December 8, 2022

**Project Location: Arby's Site Development Plan @ South Academy Highlands
4456 Venetucci Boulevard
Colorado Springs, CO 80906**

This letter is in response to the comments received August 12, 2022 regarding the Arby's Site Development Plan application submitted on July 21, 2022.

**STORMWATER STRUCTURE TABLE**

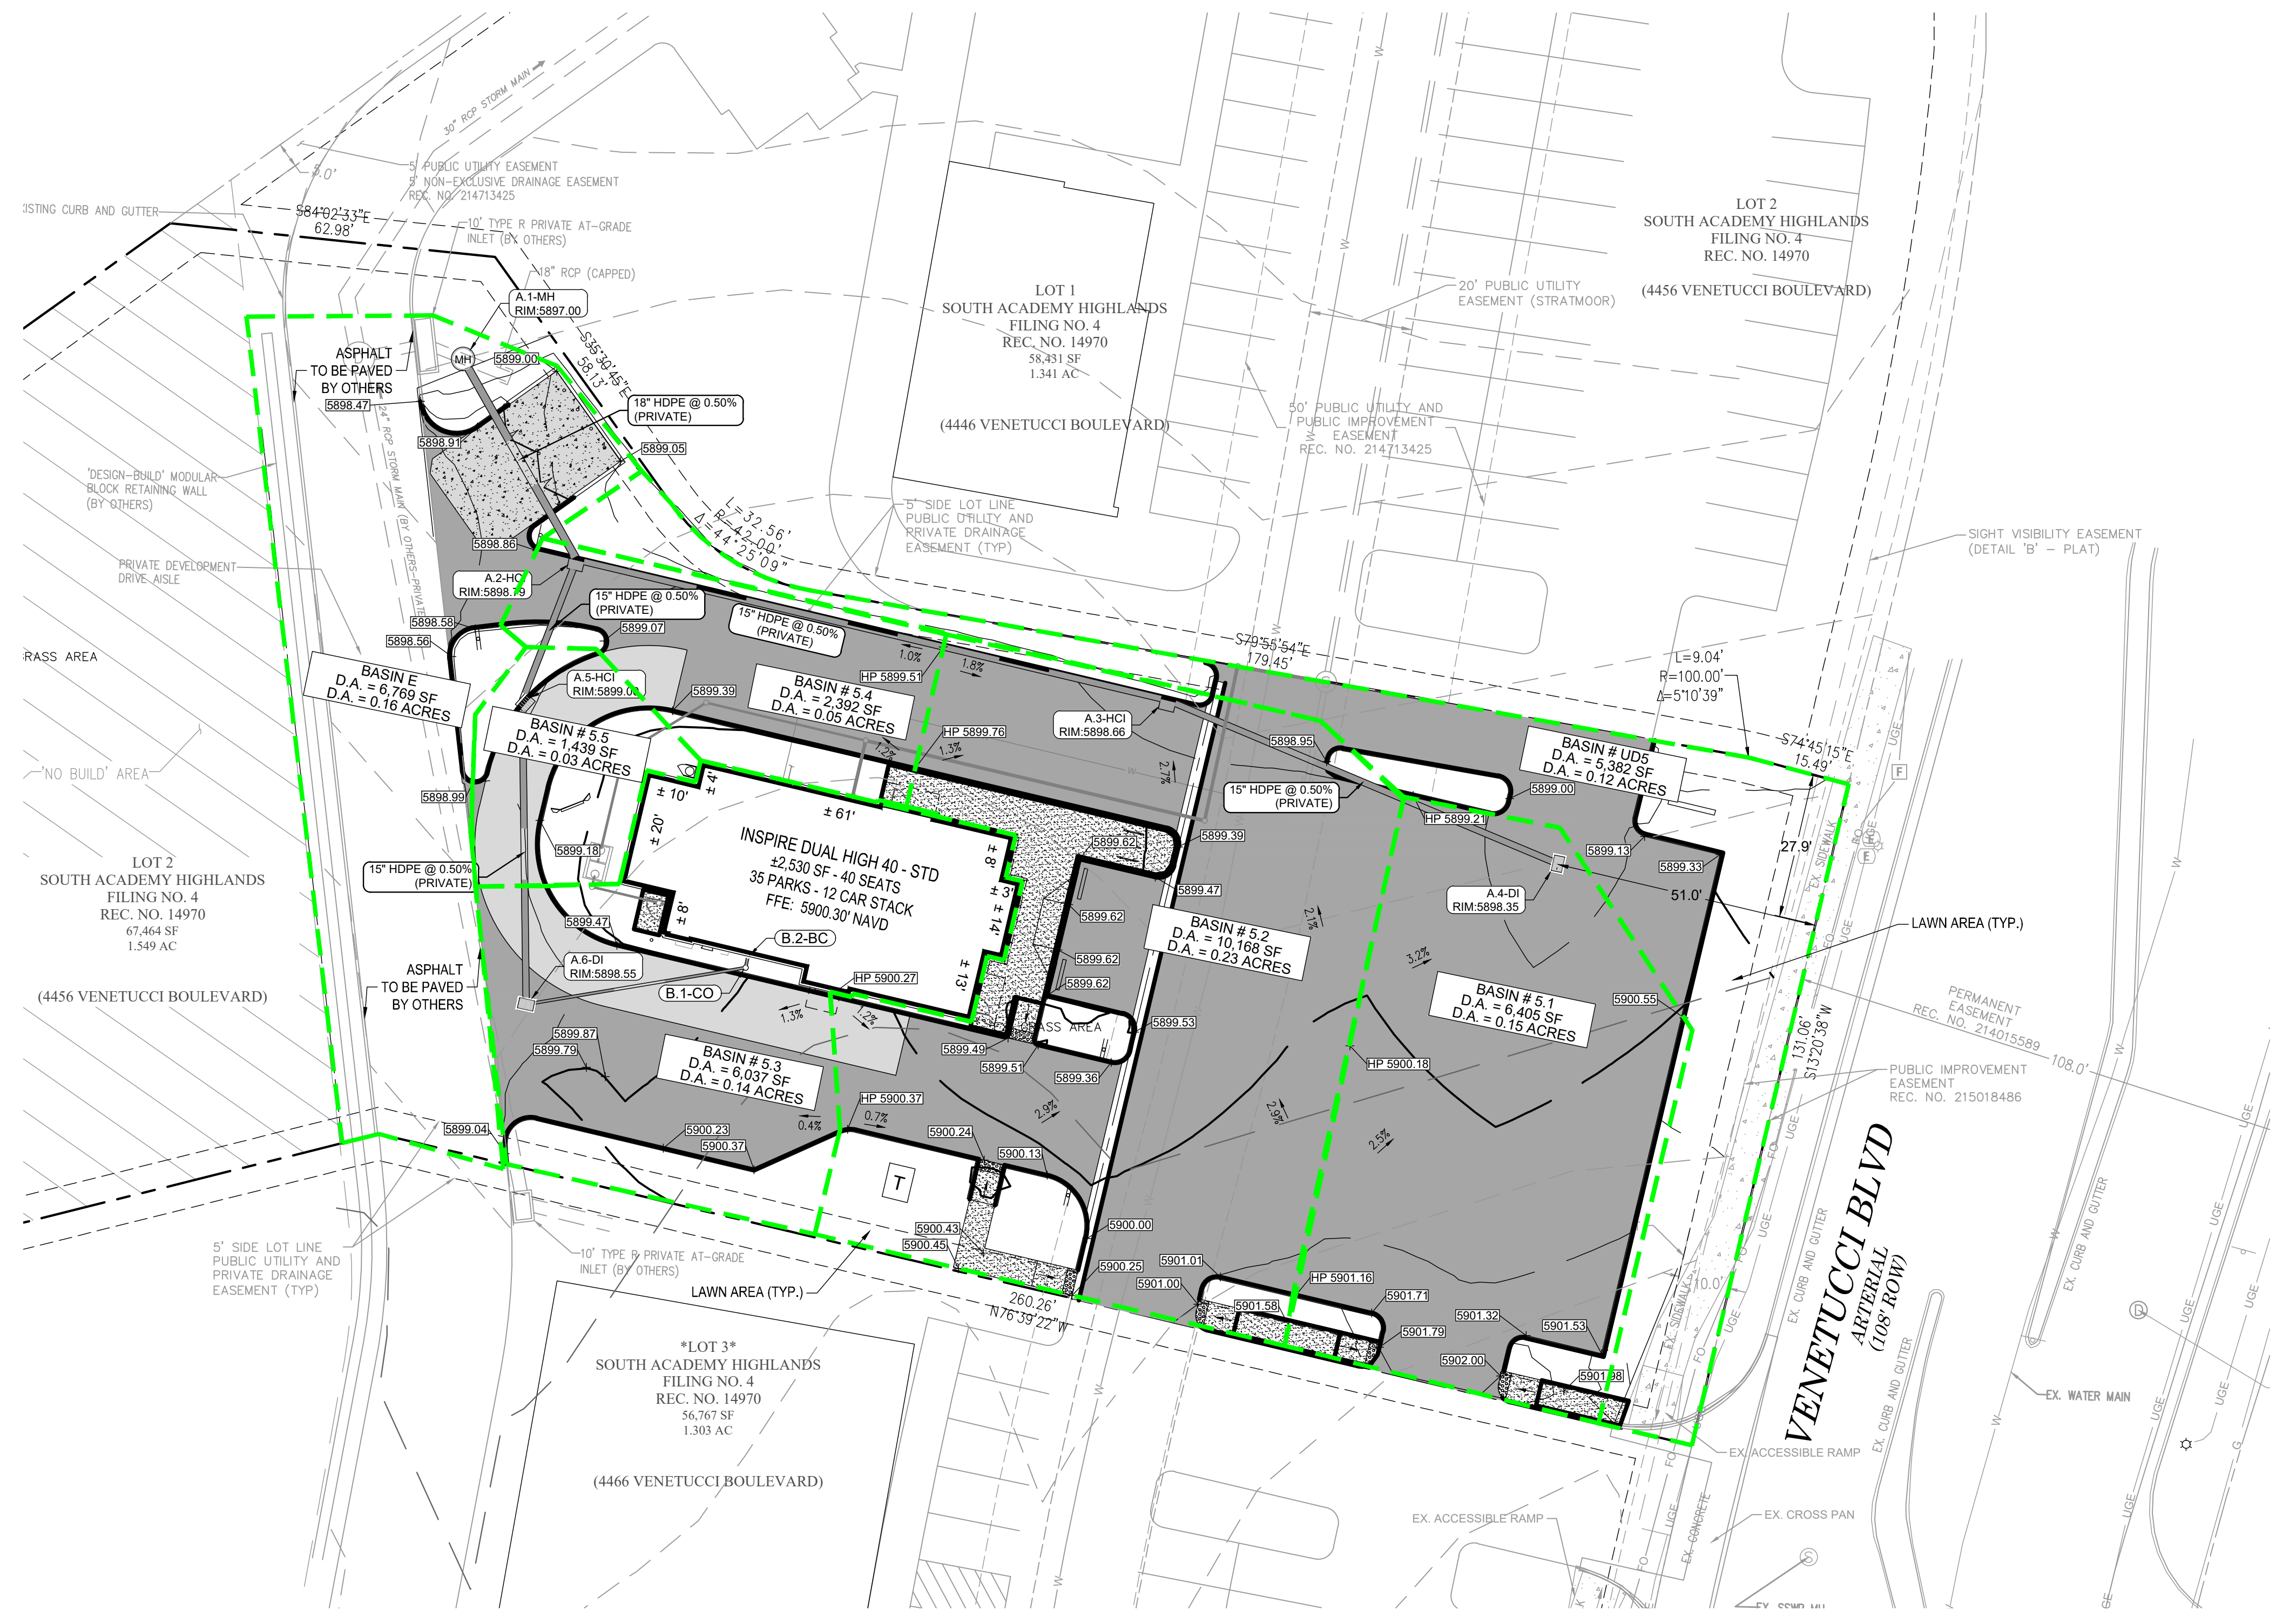
5. Need plans with elevations of water service and sewer service lines.

Response: Invert elevations for the stormwater service lines have been added to the Grading and Drainage Plan. Please see Stormwater Structure Table on sheet C-8. Invert elevations for the sanitary sewer lines have been added to the Utility Plan. Please see Sanitary Sewer Structure Table on sheet C-10.
